Application for a Non-Material Amendment Following a Grant of Planning Permission

Erection of single storey side/rear extension.

77767/APP/2023/1355

Changes to fenestration of the rear extension element, reduction of roof form from pitched glass to flat roof, and changes to internal layout.

Stage: Planning	Job Title: Single Storey Side & Rear Extension	Job Number: 12MC	Drawing Number: 03
	Client: Wafic Fawaz	Scale: 1 : 100 @ A3	Revision Suffix: B
Drawing Title: Proposed Floor Plans	Site Address: 12 Marsworth Close, Hayes, UB4 9SZ	Date: 13/10/2023	Drawn By: GU Checked By: AA

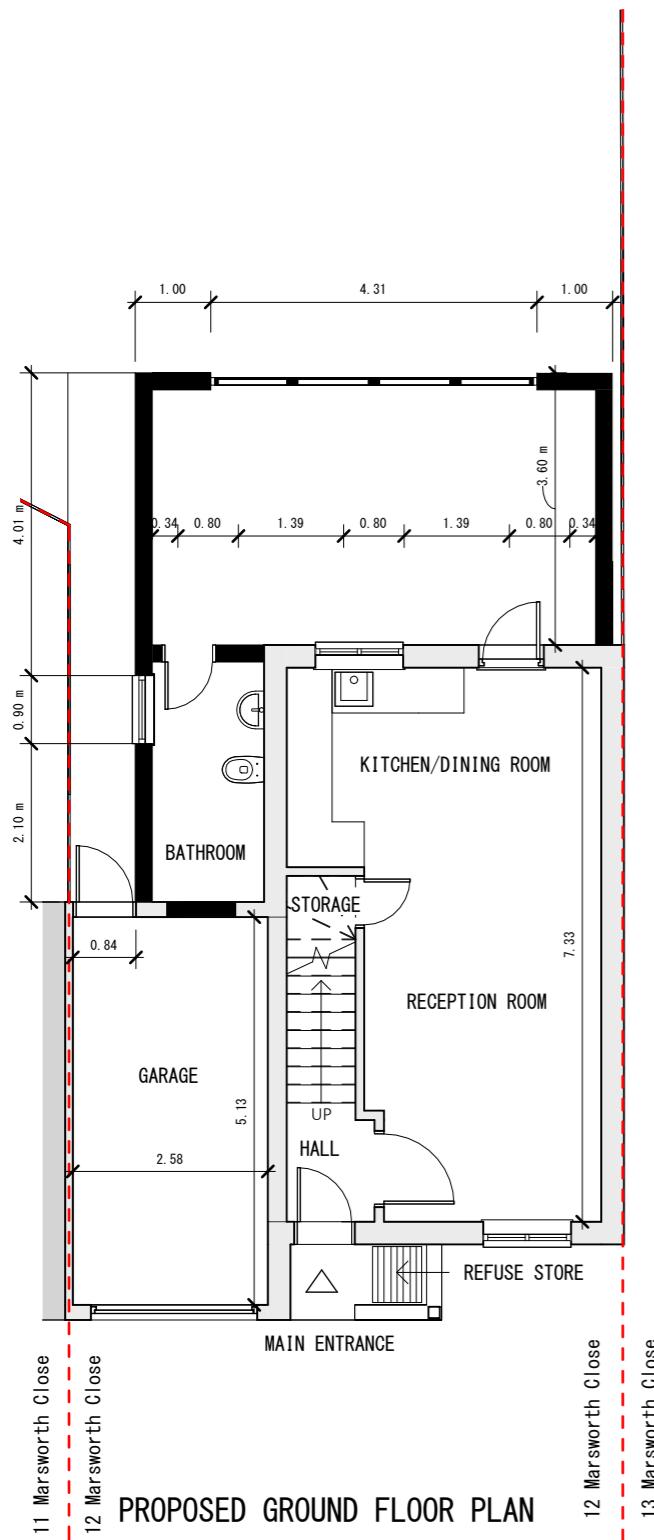
1. Obscured glaze along number 13 Marsworth to be replaced with bricks to prevent overlooking, daylight will be restricted due to existing boundary fence.
2. Pitched glass roof to be replaced with flat roof to match proposed side extension roof form and neighbouring extension roof form at number 11 Marsworth.
3. Introduction of rear extension masonry columns of both sides of the patio doors to allow structural engineer to design suitable lintel(s) to support the patio door opening and roof structure.
4. Move proposed bathroom into previously proposed utility room, to create a larger living space in the proposed extension.
